From: Tim Murray [REDACTED]
Sent: 30 January 2015 16:42
To: Janice Chapman
Subject: Re: FP/219/14/HH - Ground & First floor extensions and loft conversion at 1 First Avenue, Felpham

From: Janice Chapman
Sent: Friday, January 30, 2015 12:28 PM
To: [REDACTED]
Subject: FP/219/14/HH - Ground & First floor extensions and loft conversion at 1 First Avenue, Felpham

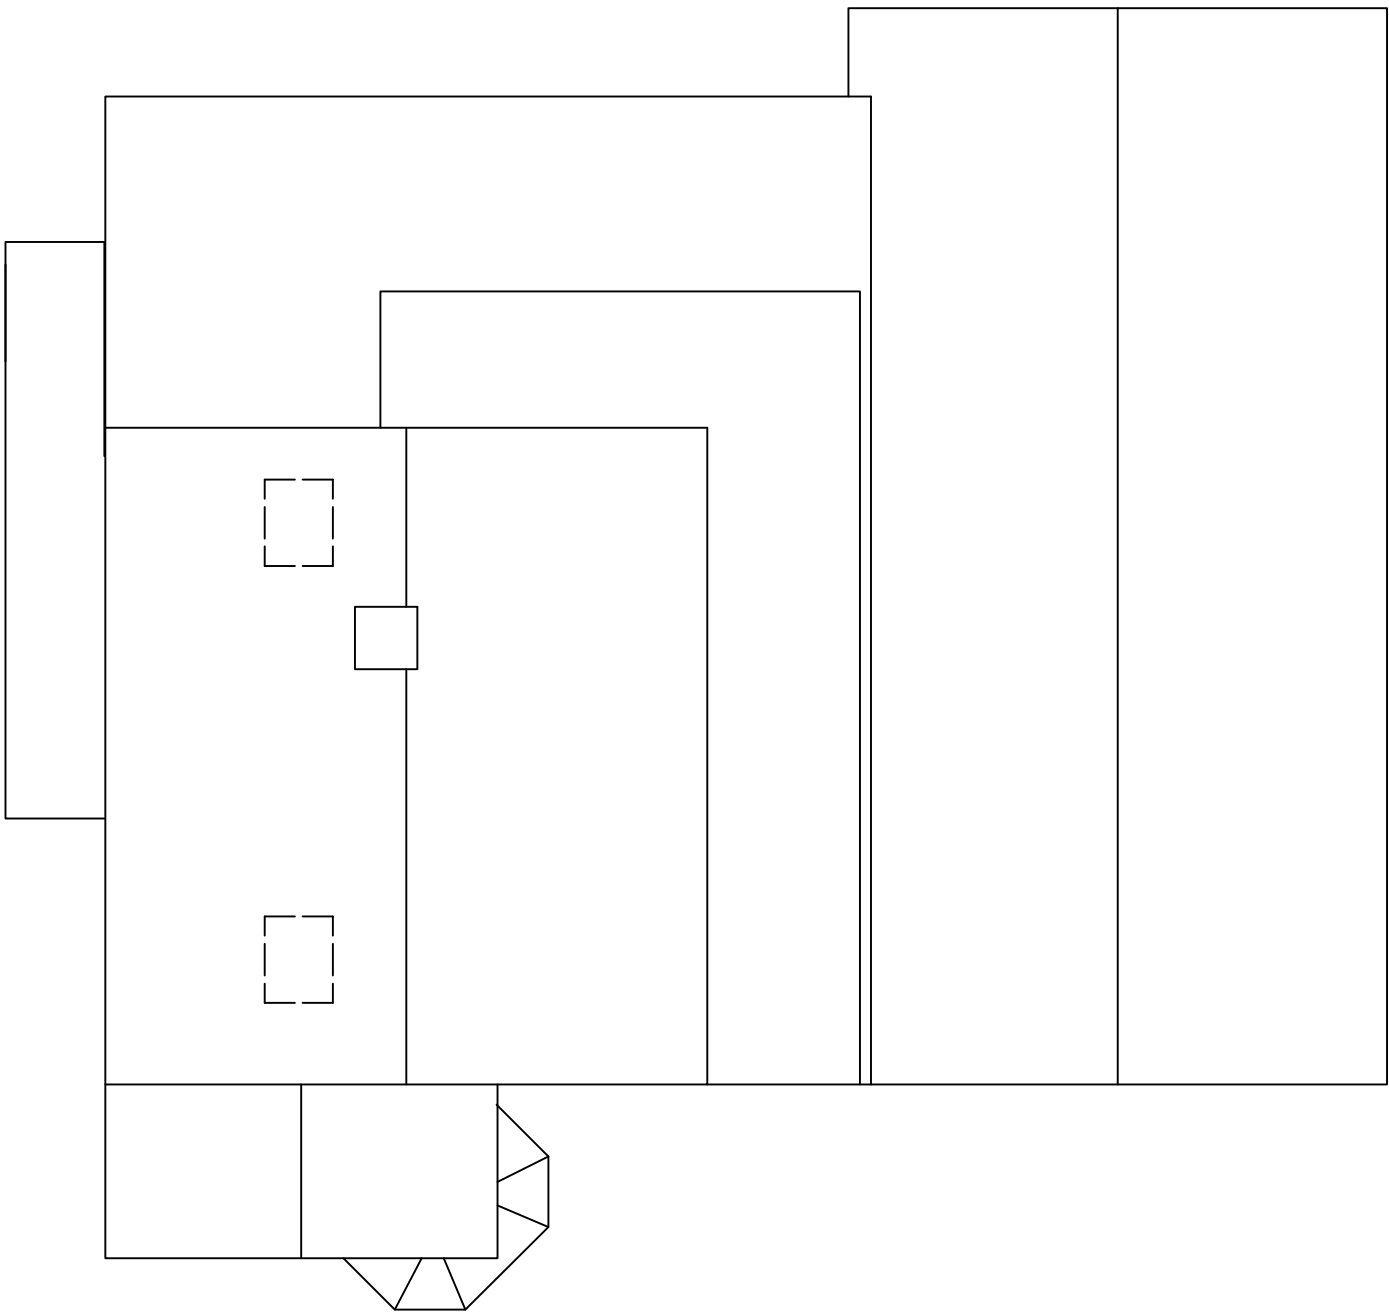
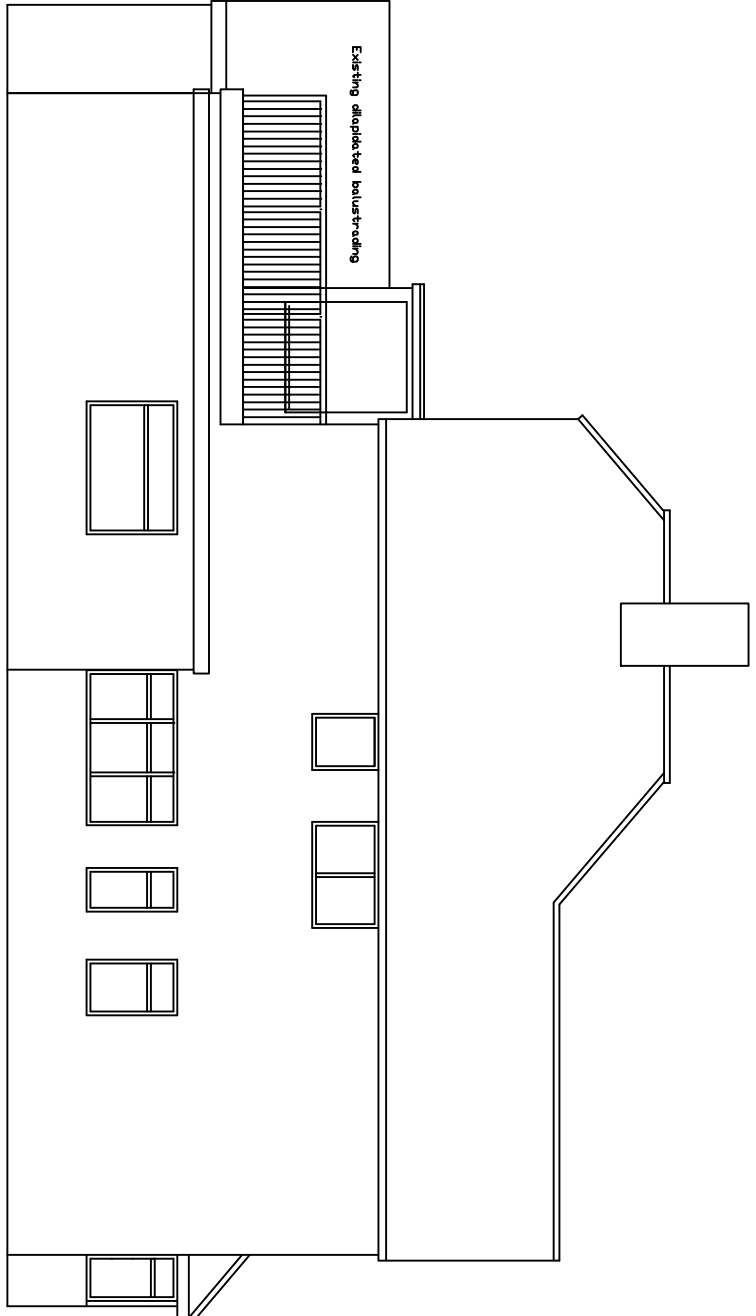
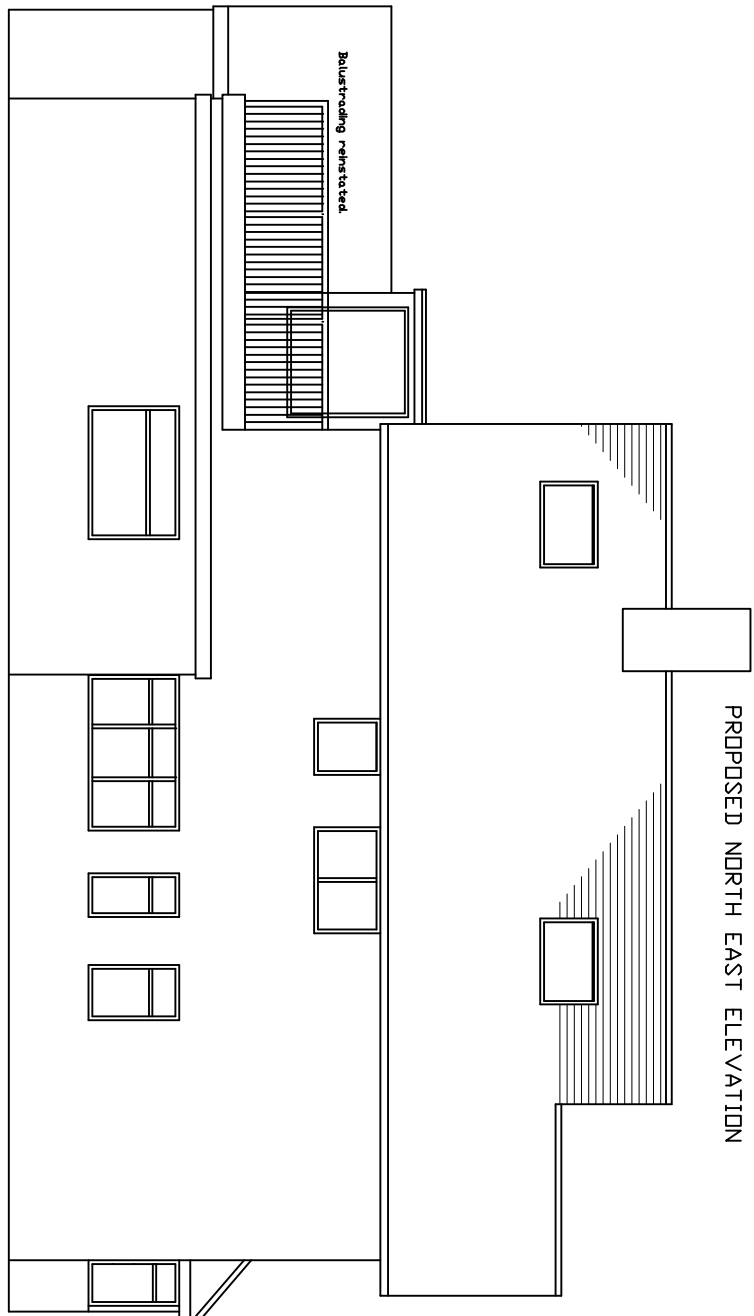
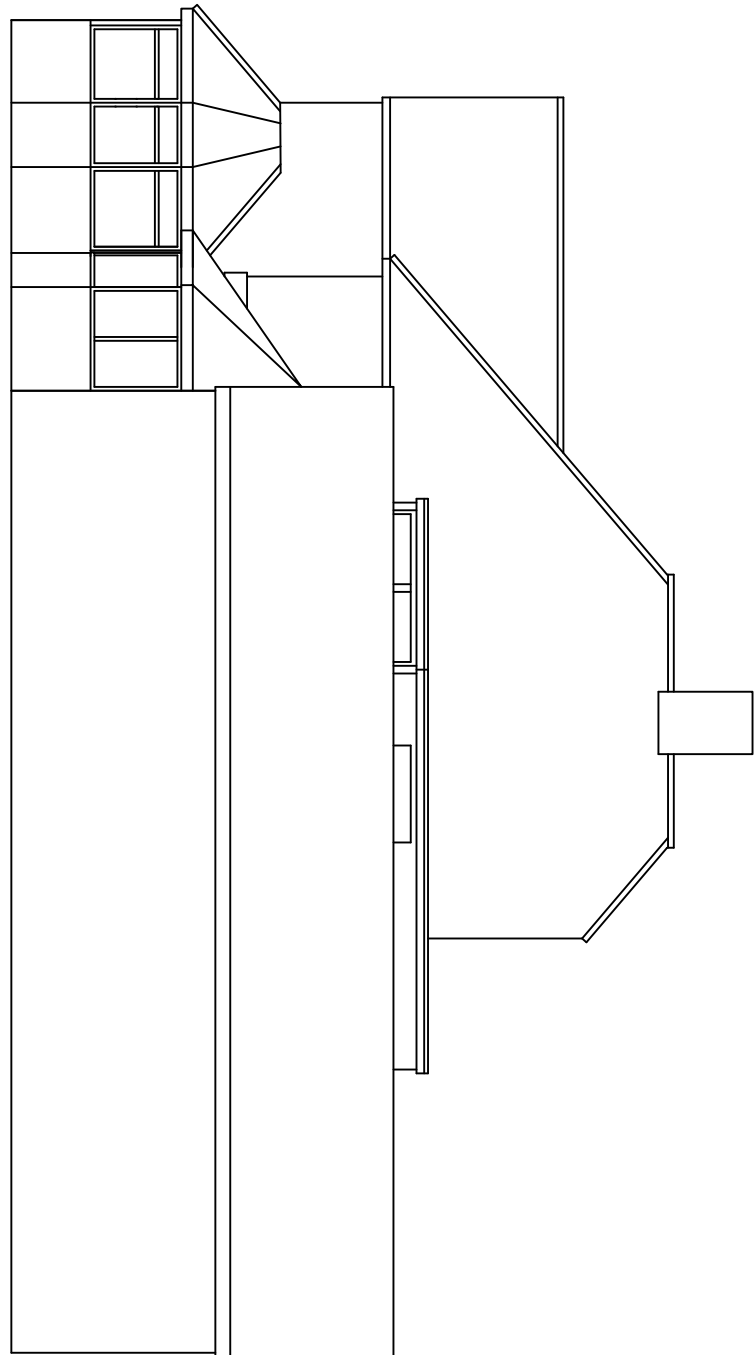
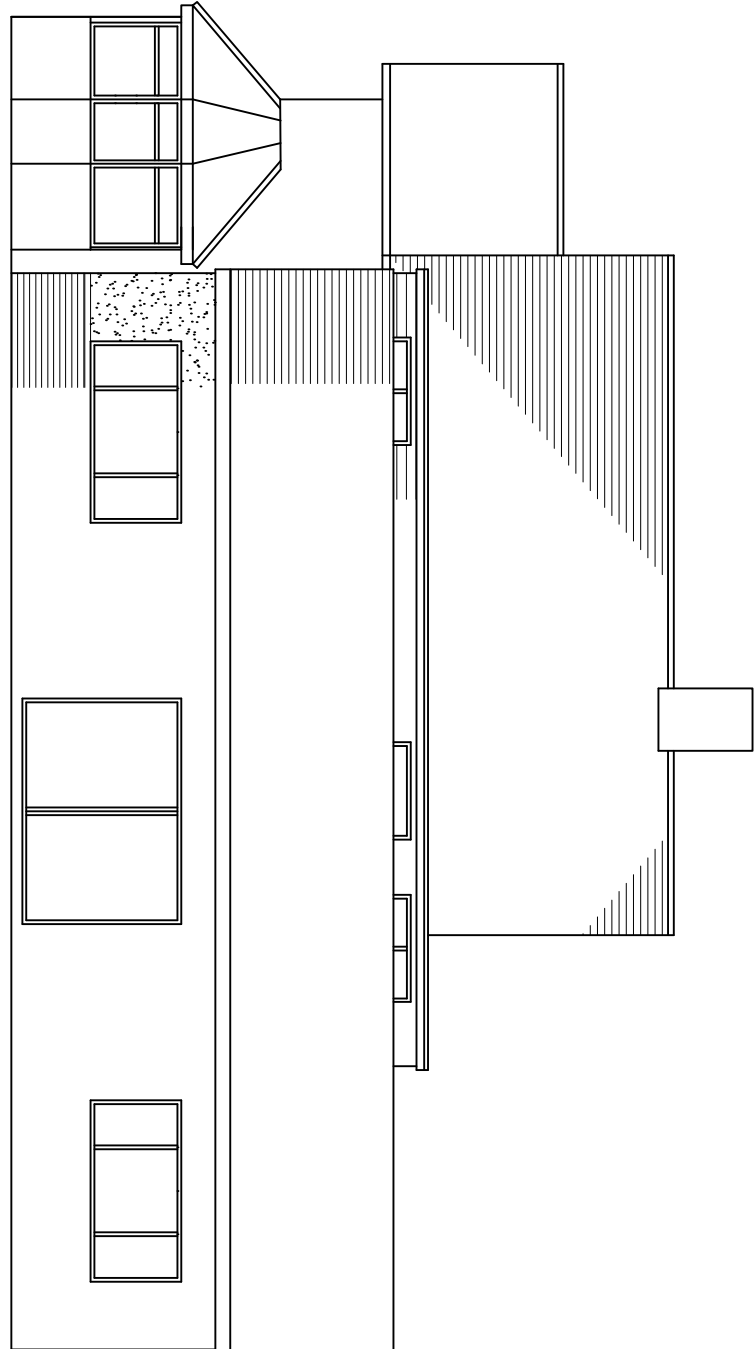
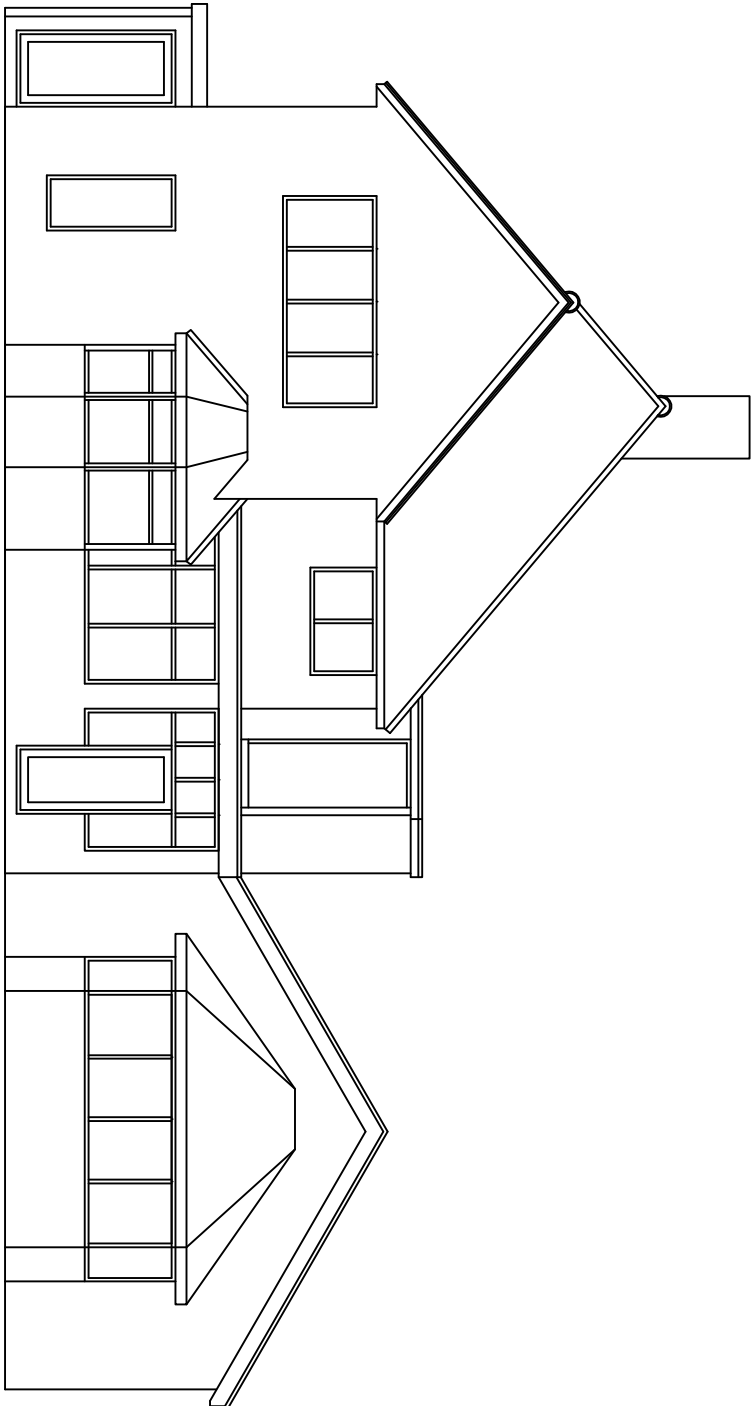
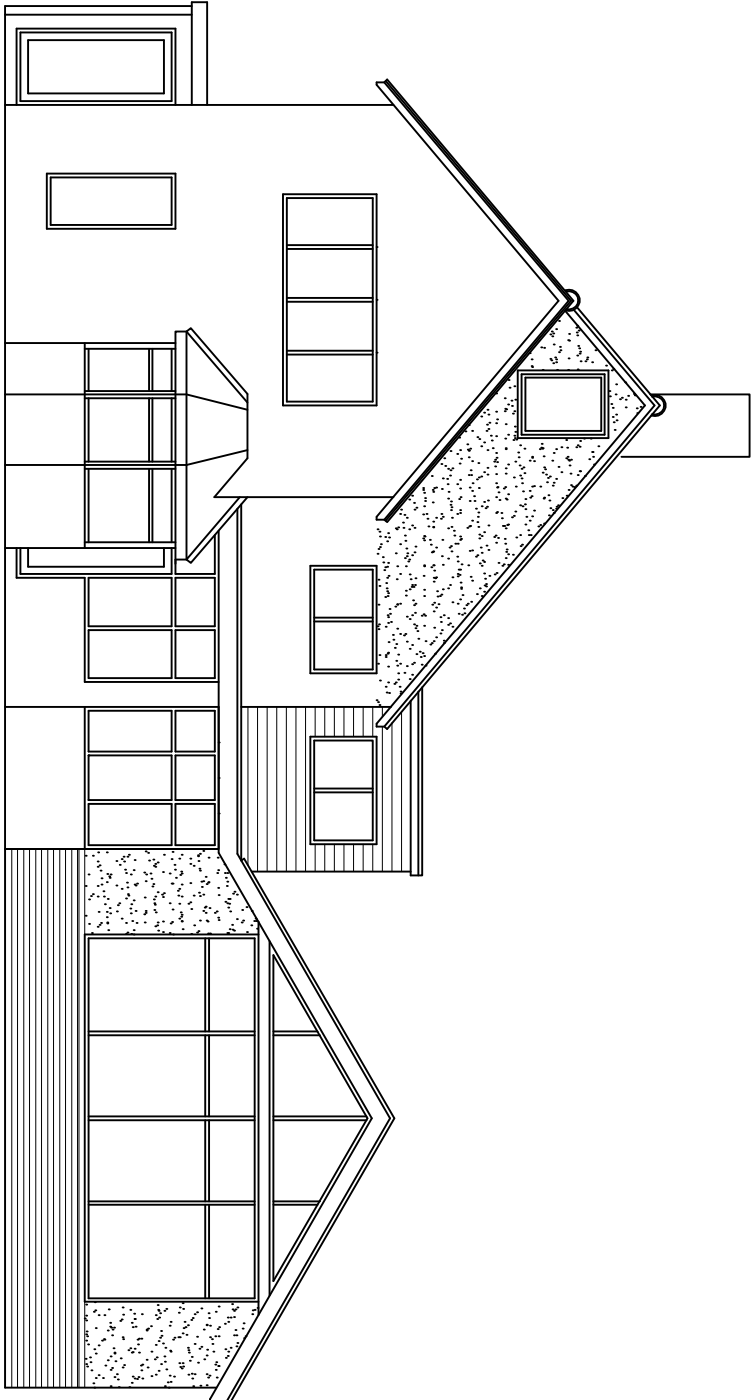
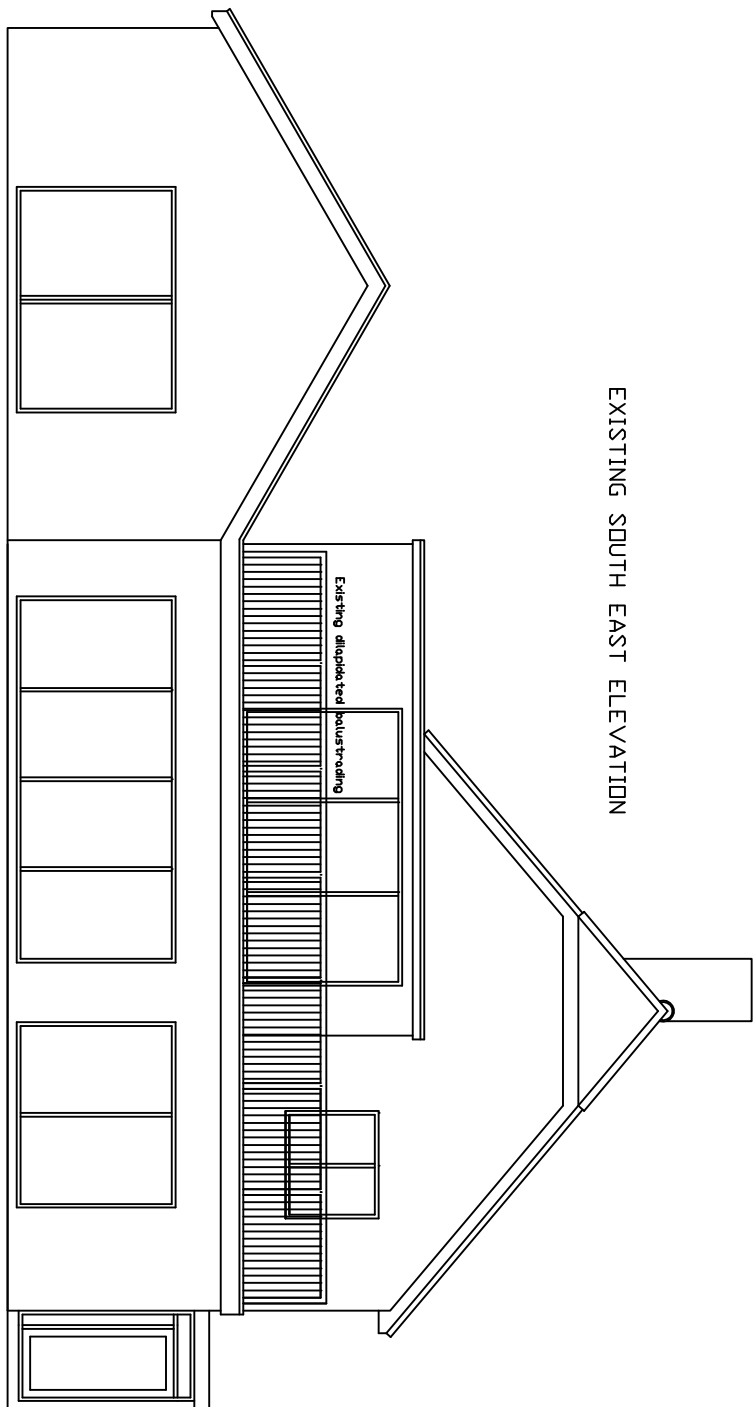
From a site visit the submitted elevations appear to be incorrect. The front elevation facing First Avenue is north west should be south west, etc. Can you please amend.

Amended plans attached.
